OUT21/8284

**Hydro Kurri Kurri Aluminium Smelter Remediation Mod 1 (SSD 6666)  
Modification Report**

Senior Project Officer, Assessments, Knowledge Division  
**Department of Planning, Industry and Environment: Water**  
17 July 2021

**Figure 2 |** Proposed location of leachate management infrastructure

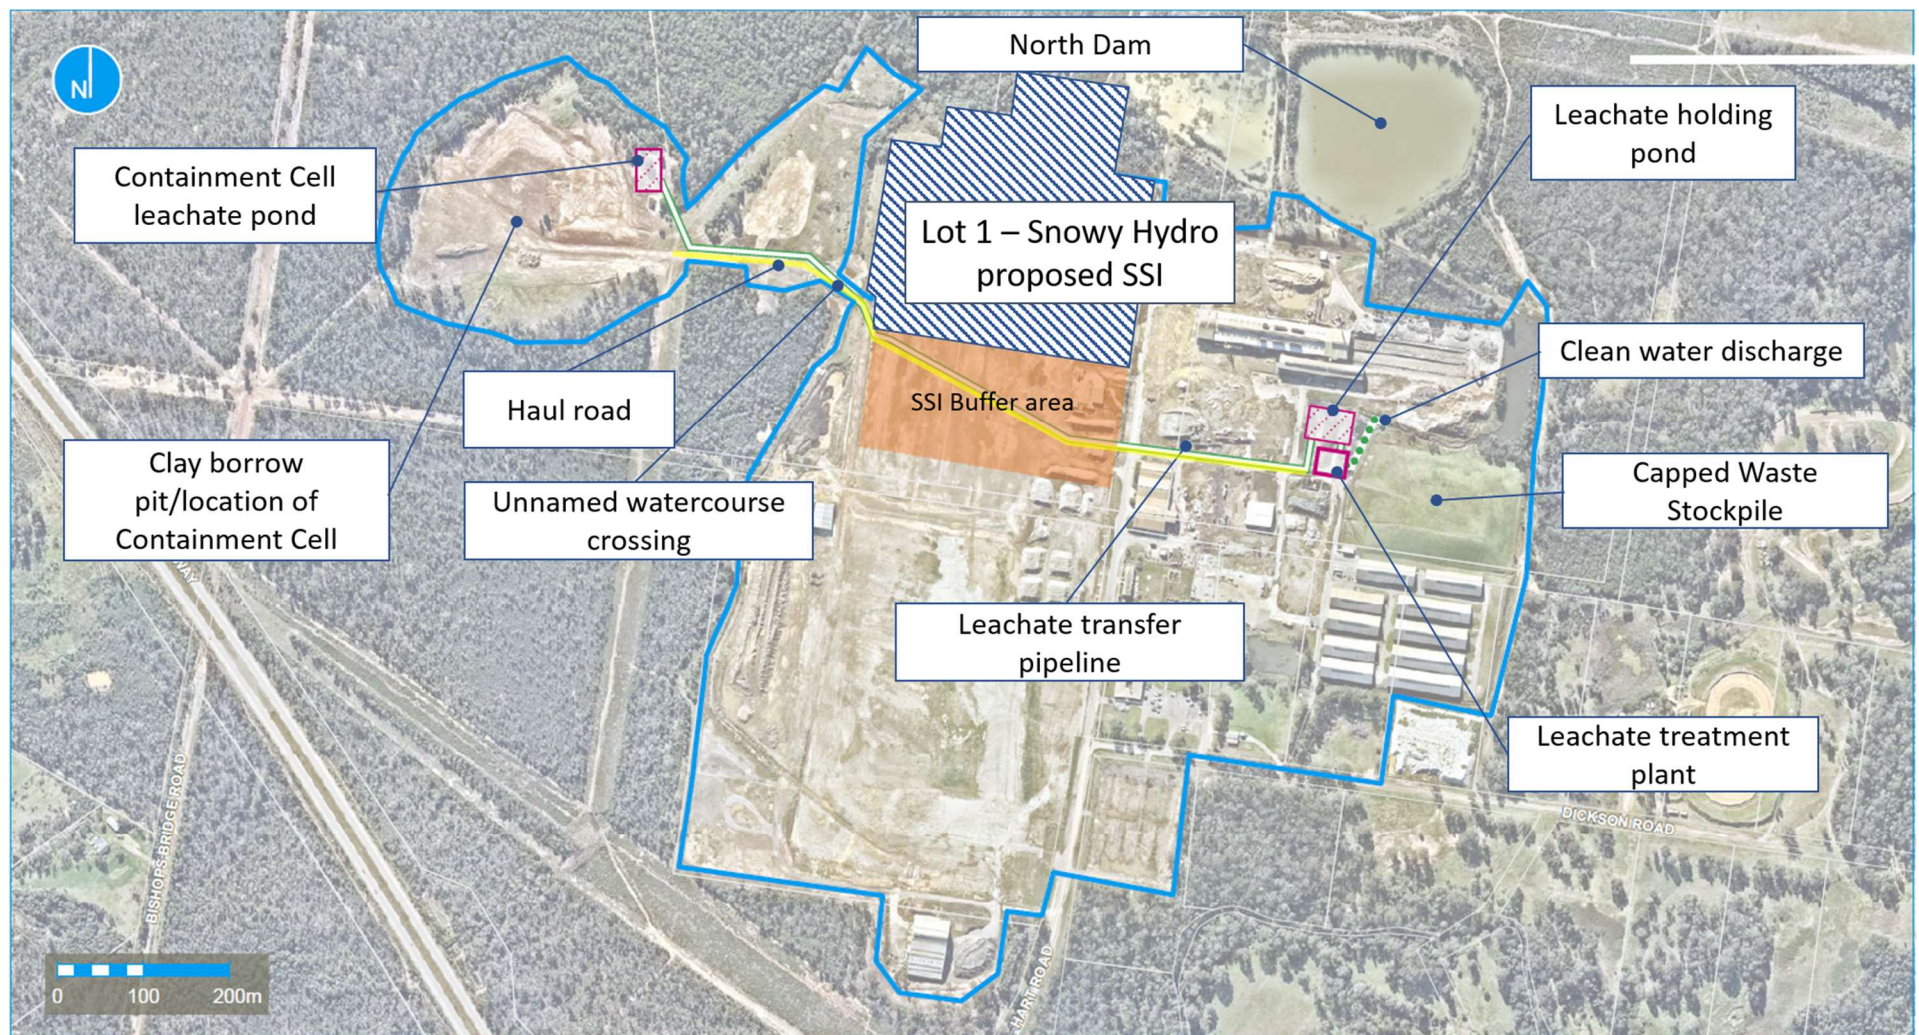
- The pipeline is proposed to cross a second order watercourse. The proponent must provide the location of the crossing or confirmation that it will be on top of the existing culvert. If it will be through the watercourse, the proponent must provide details for method of crossing.
